WELWYN HATFIELD COUNCIL – DEVELOPMENT CONTROL
DELEGATED REPORT

APPLICATION No:	S6/2012/0338/LUP
APPLICATION Site:	45 Kentish Lane, Brookmans Park

DESCRIPTION OF PROPOSAL:

PROJECT: Proposed extension, loft conversion & alterations DRAWING NUMBER: 10015/3A

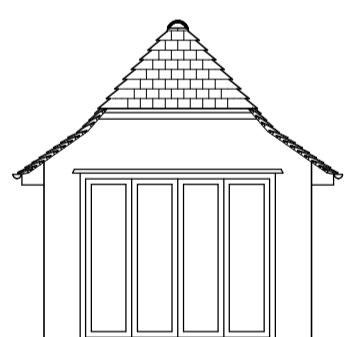
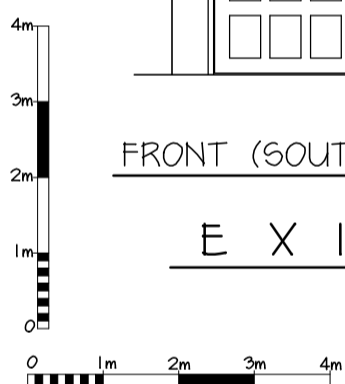
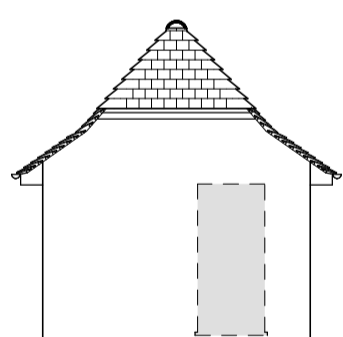
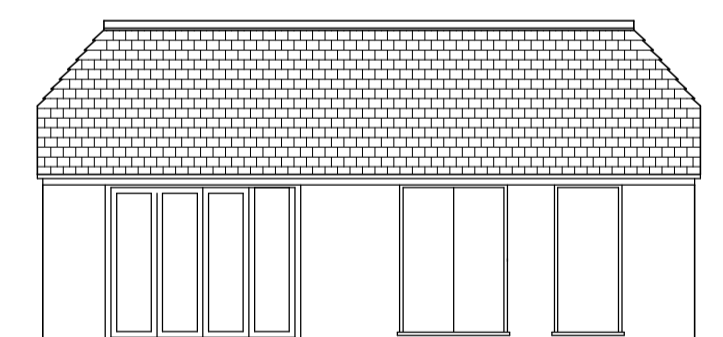
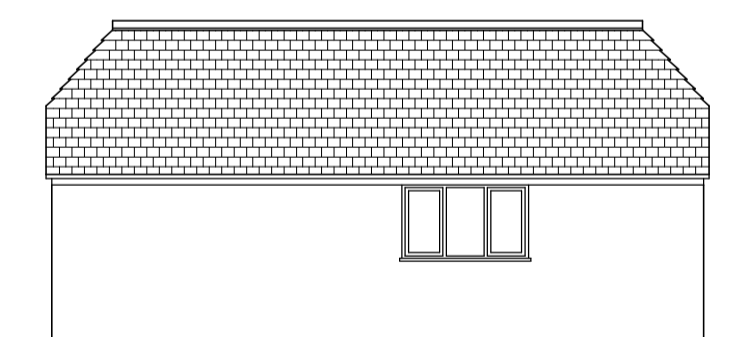
Class E relates to the conversion of the existing garage to a pool bar/plant room/changing room

The proposed pool bar/changing facilities is a conversion of an existing outbuilding with no changes proposed to the height.

The height of the eaves of the proposed double garage does not exceed 2.5m

PROJECT: Proposed extension, loft conversion & alterations DRAWING NUMBER: 11015/15

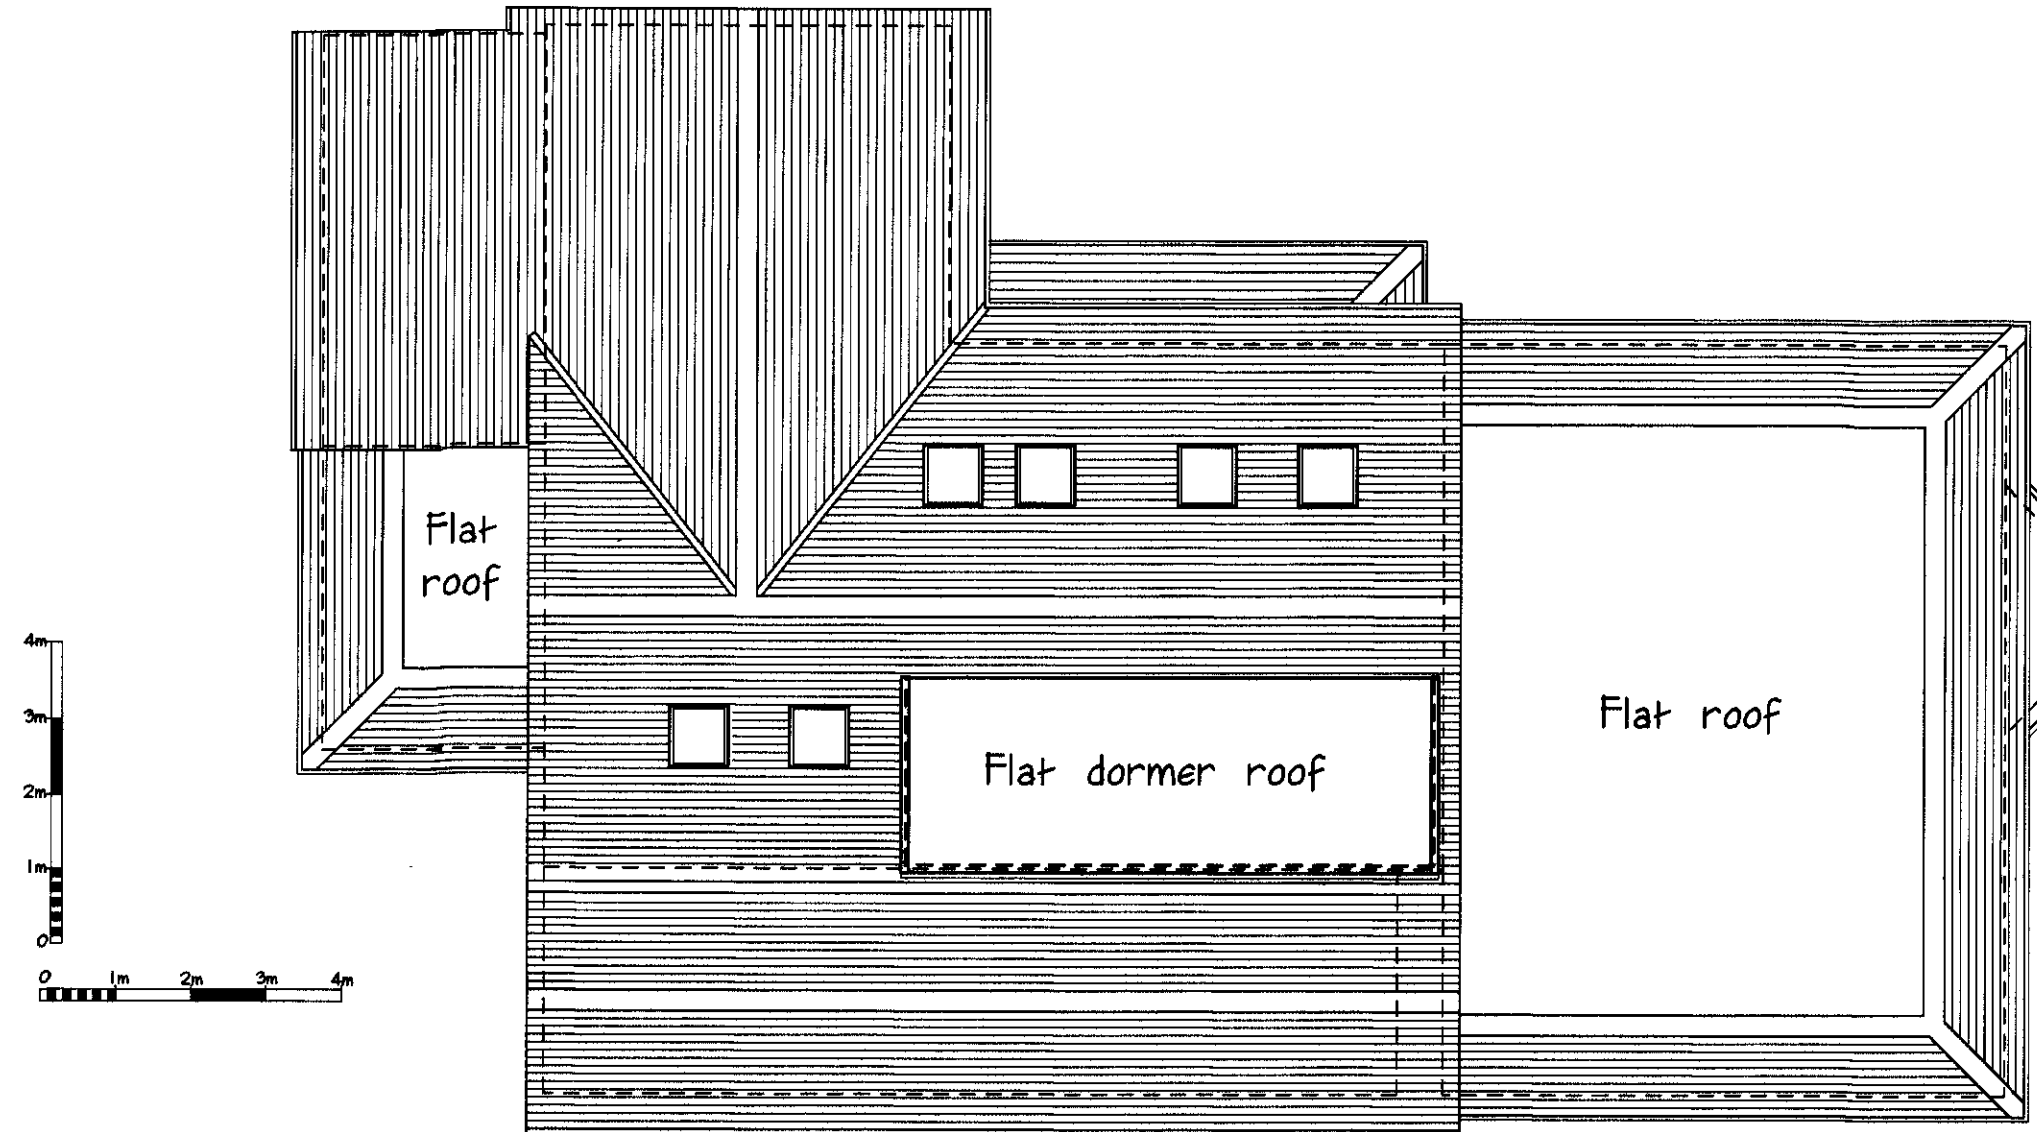
Class C relates to the rooflights proposed on the front, rear and north eastern side elevation of dwellinghouse

The proposal would not protrude more than 150 millimetres beyond the plane of the original roofslope

The proposal would exceed the height of the highest part of the original roof
